One Earth Solar Farm

**~~Draft~~ Final Statement of Common Ground with the
Environment Agency**

EN010159/APP/8.11.54

December 2025

Figure 9: Site Defended Fluvial Design Maximum Flood Extent: DEF\_F0100\_CC39\_T0002 (Base map: OpenStreetMap © <https://www.openstreetmap.org> and contributors. Ordnance Survey licence number 100024198).

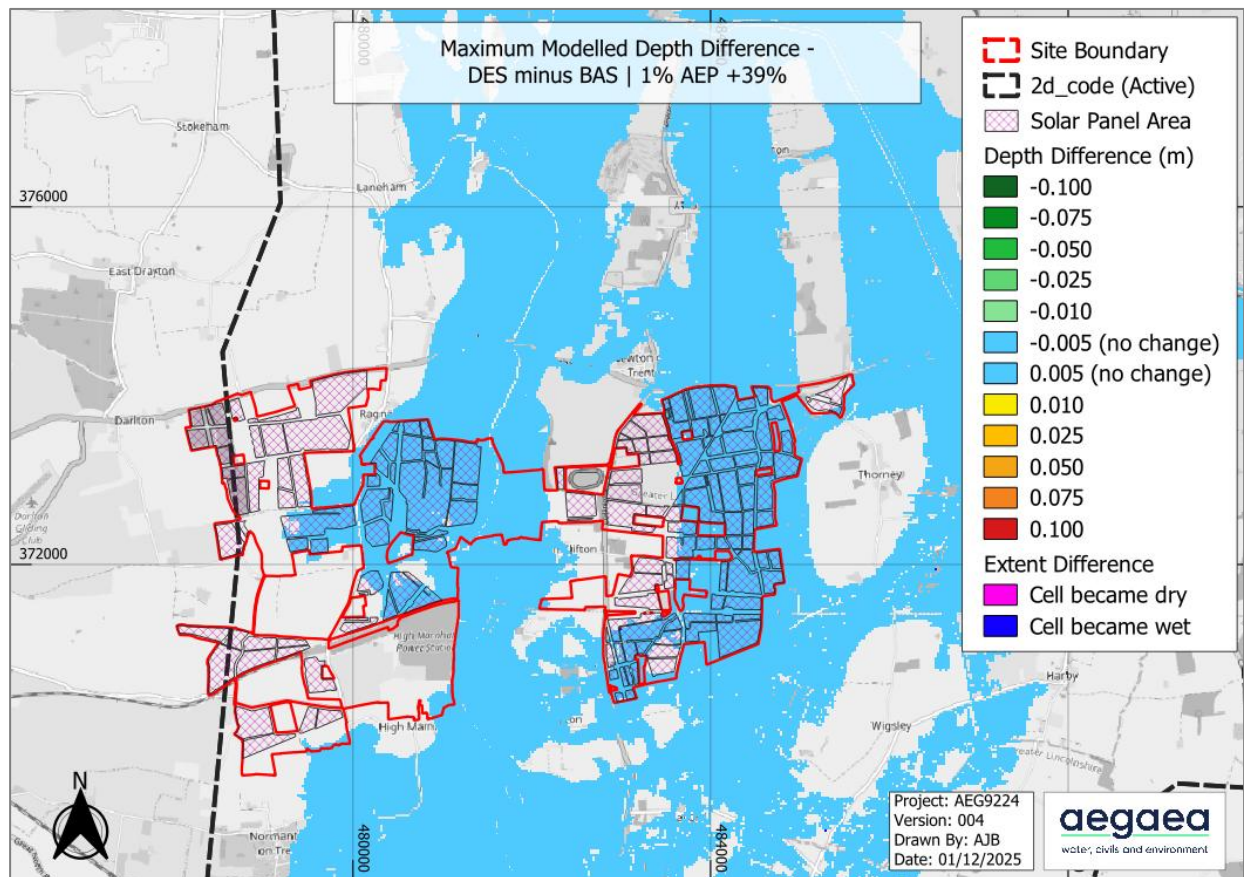
02-09	Flood Conveyance	Applicant to consider the impact on flood flow conveyance due to panel	Hydraulic modelling has been completed by the applicant to account for the potential loss in floodplain storage and flow constriction. The Environment Agency have undertaken a review of the hydraulic modelling and are satisfied with	Under Discussion Agreed

mounting structures (i.e. supports).	<p><u>the approach taken. The approach to the modelling is described in the updated Flood Risk Assessment (pages 34-39) and water level difference mapping is also presented.</u></p> <p><u>This confirms that there would be a negligible increase in flood levels (within the 5mm model tolerance) and flood extent outside of the Order Limits which is not considered to result in additional risk to receptors. There are only minor changes in flood hazard rating in the proposed scenario which are either within the Order Limits or in areas where there are no receptors to this change.</u>Following a review of the updated FRA and Hydraulic Modelling Report (submitted at Deadline 6), it is anticipated this will be updated to “Agreed”.</p>	
02-10	WFD Screening Assessment	WFD Screening Assessment to be prepared for review by the EA.	<p>An updatedA WFD Screening Assessment was provided at Deadline 4has been prepared -4 which sets out that with embedded mitigation, no further assessment is considered necessary. This SoCG entry will be updated accordingly when the EA confirm agreement.</p>	Agreed
